DECISION DELEGATED TO HEAD OF PLANNING

Application No:	H16-0637-22	Applicant:	Mr F Mir Javadi
Proposal:	Extension & alterations to 98 London Road and erection of pair of semi-detached dwellings to the rear		
Location:	98 London Road Spalding		
Terminal Date:	14th September 2022

BLOCK & LOCATION PLANS

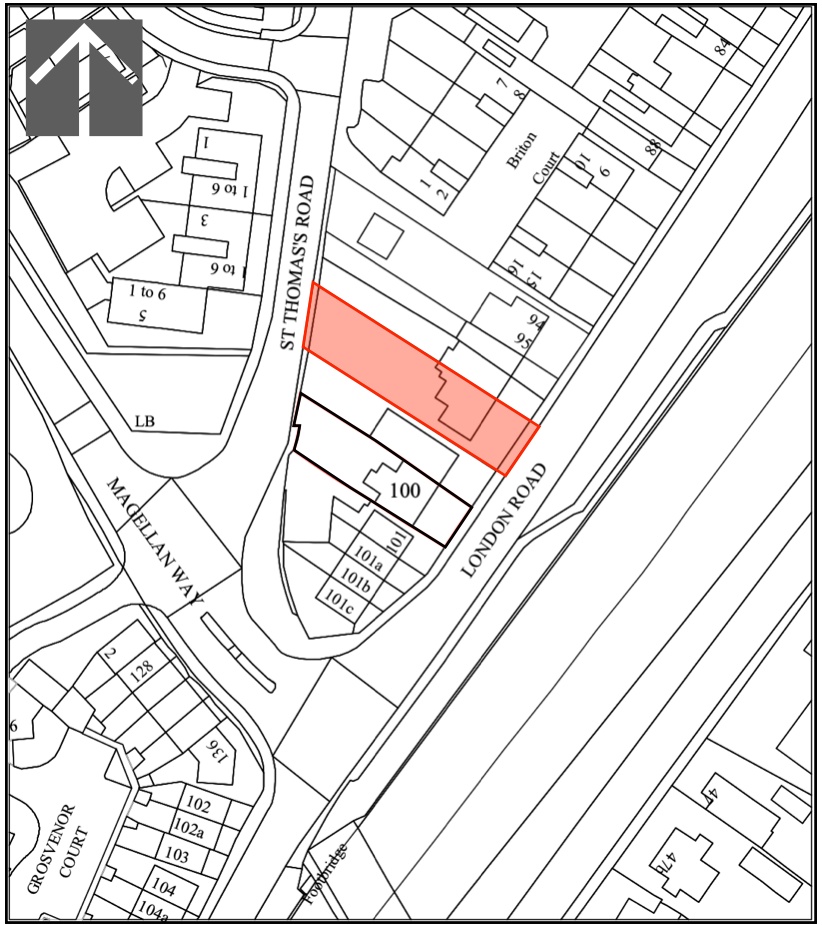
4. The proposed vehicular accesses for 98 London Road and the two new dwellings will provide one off road parking space. The level of off road parking provision does not accord with the minimum amount of two off road spaces per dwelling as required under Appendix 6 of the SELLP.

Overdevelopment - The plot sizes are significantly smaller than those of any other dwellings in the vicinity. Gardens are minimal and not enough space has been provided to provide enough off road parking provision.

5. There is a small amount of space for bicycle and bin storage that will further reduce the already small garden space for each of the three dwellings. The proposed vehicular accesses for 98 London Road and the two new dwellings will provide one off road parking space. The level of off road parking provision does not accord with the minimum amount of two off road spaces per dwelling as required under Appendix 6 of the SELLP.

approximately 18 metres away from the windows serving the flats at Cygnet Court. The recommended minimum separation distance is 21 metres and therefore these windows are considered to create a material overlooking aspect. There is considered to be a material overlooking aspect to the rear elevation windows and proposed garden spaces due to the location of the windows at 99 London Road to the south east.

Overshadowing - Due to the extension at 98 London Road being sited to the north of 99 London Road, there is considered to be a material overshadowing and overbearing impact on the side elevation windows of 99 London Road at ground and first floor level during early daylight hours. There is considered to be a material overshadowing impact on the garden spaces and rear windows of Plots 2 and 3 due to the two storey dwelling at 99 London Road to the south as well as the two storey height of Plots 2 and 3 to the west on the garden spaces provided.
